Your Ref: OWPC6364
Our Ref: LU/203/15/PL
Please ask for:
Mrs A Gardner

Application for removal of condition 7 imposed under Appeal APP/C3810/A/09/2112099
(LU/517/04) relating to provision of security gates
Littlehampton Market 26 Surrey Street Littlehampton

Drawing
Site Plan
Setting Out

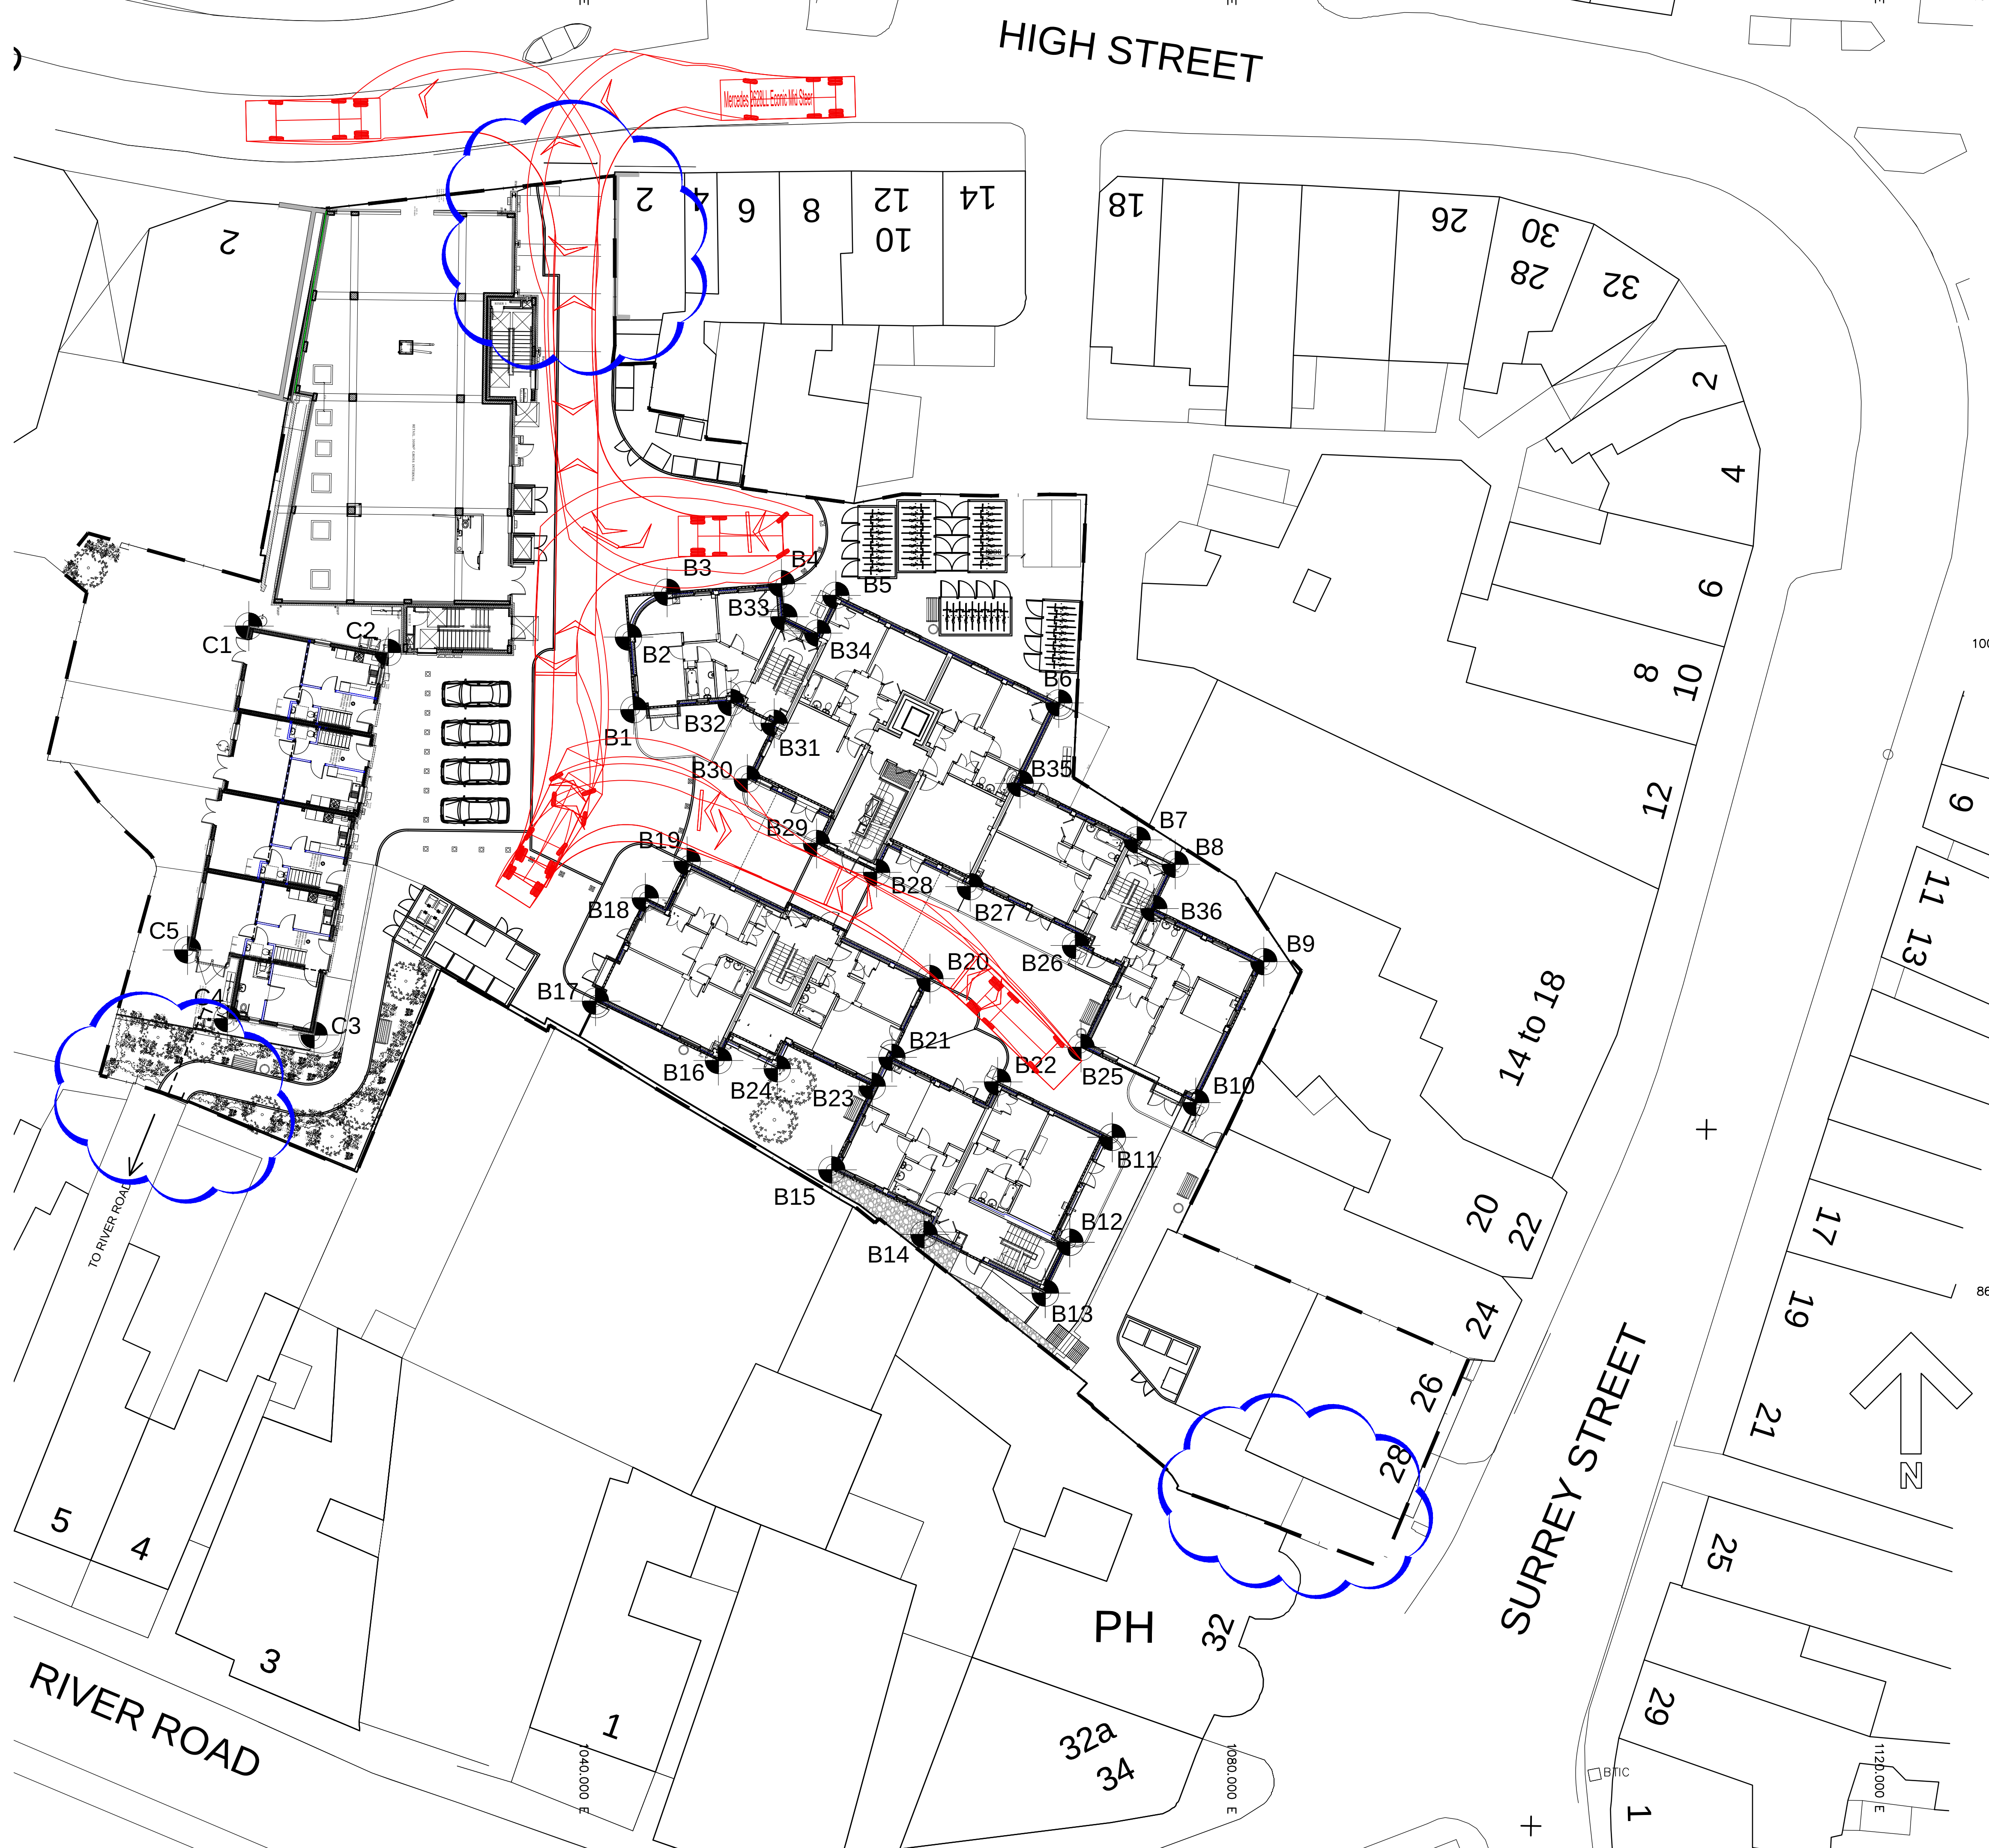
The Town Council's Planning and Transportation Committee considered this matter at their meeting on 20th July 2015 and object to the application. Whilst Members had no objection to the proposed change to the vehicular access at Terminus Terrace / High Street, serious concerns were expressed about the proposals to remove the pedestrian gates at Surrey Street and River Road. Noting that the gates had been imposed as a condition of approval by the Inspector to control access and as a security measure, it was the view of the Committee that the removal of the gates at these points would allow unfettered access that would compromise the safety and security of those living in the area.
